From: Chris Holland
Sent: Tuesday, June 28, 2022 2:51 PM
To: David Morse
Cc: Haylie Miller; Ken McIntyre; Emily Morgan; Amy Hess; Kathryn Bird; Michael Beck; Janis Lamoureux
Subject: Marysville 44th PRD (PA22024) - Incomplete

After reviewing the application materials submitted for Marysville 44th PRD the application has been determined to be ***incomplete***.

CONCEPTUAL SEWER PLAN
7315 & 7417 - 44TH ST NE
MARYSVILLE, WA
PARCELS 3005350030-3600,-3700

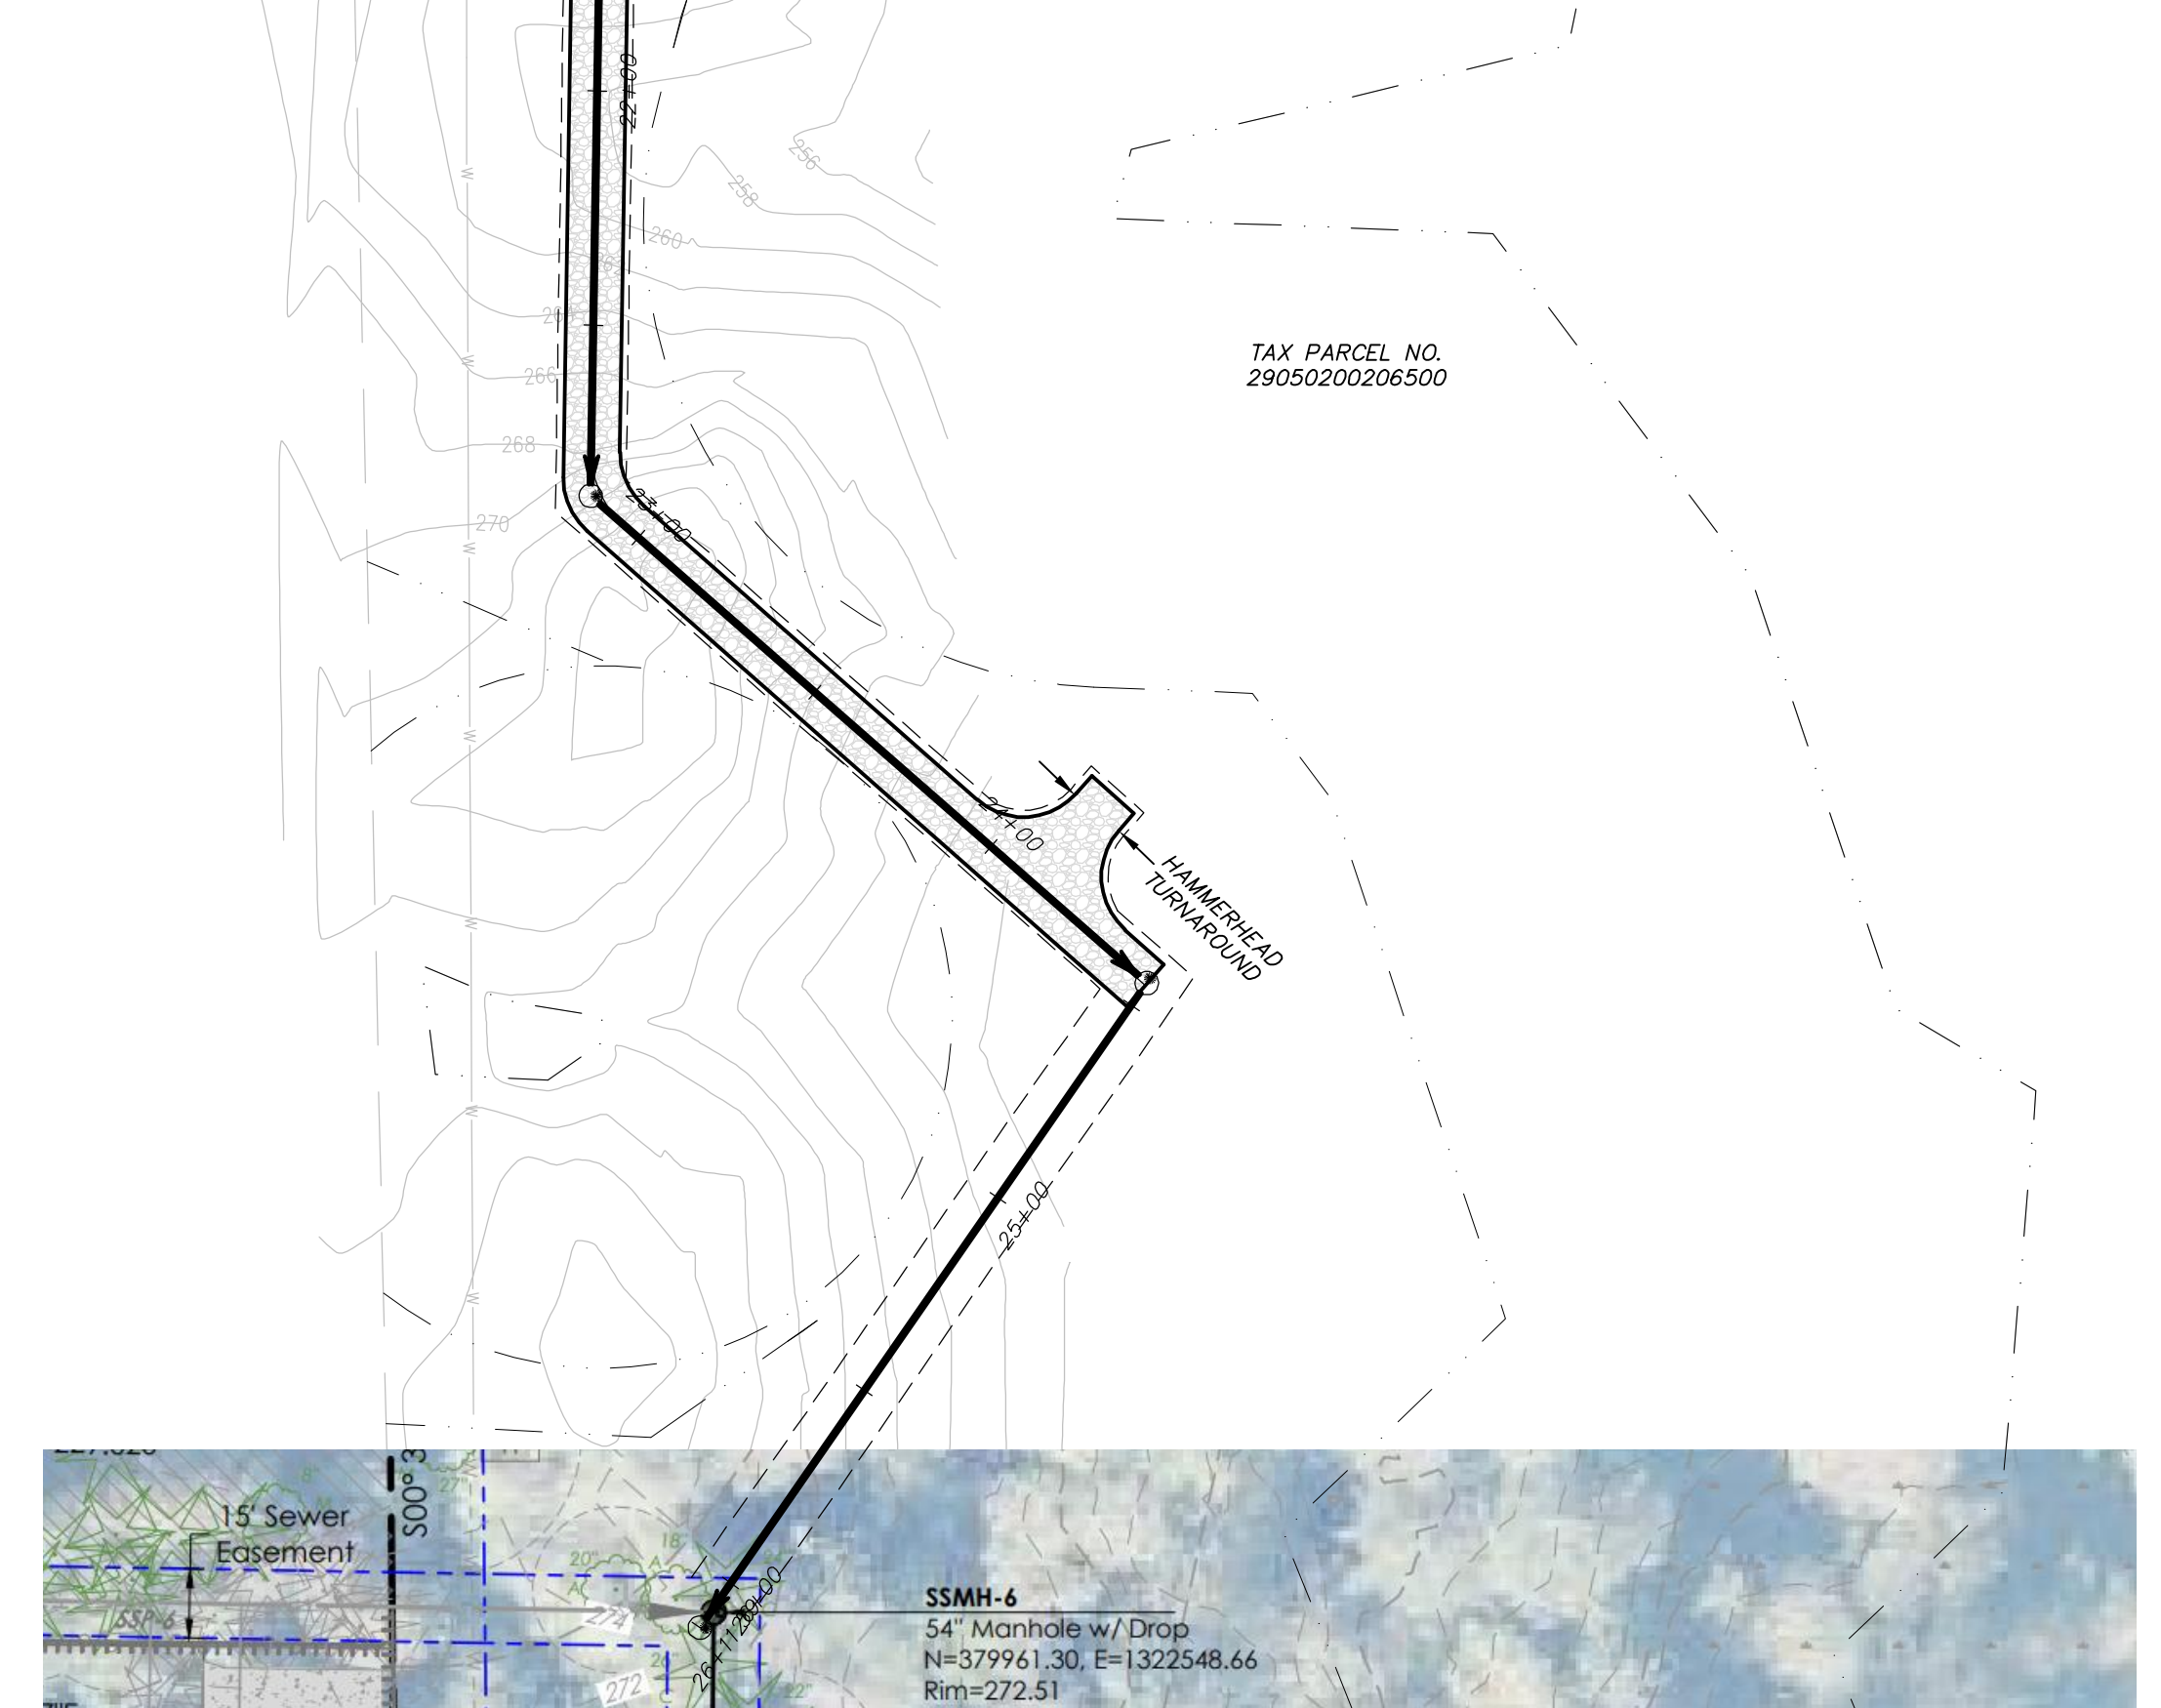
- Critical Areas Impacts and Preliminary Mitigation Plan related to the proposed off-site sewer located on the City of Marysville Parcel APN 29050200206500. This shall include identifying temporary and permanent impacts and proposed mitigation;
- Amend the Preliminary Civil Construction plans to identify the proposed access to the off-site sewer manholes on the preliminary civil construction plan, including proposed access turnaround and type of construction;
- Amend the Preliminary Drainage Report to identify how stormwater is proposed to be treated for the construction of the proposed access to the off-site sewer manholes; and
- A Traffic Impact Analysis is required to be prepared and submitted with the formal Land Use Application. Currently, a traffic scoping memo has been provided.
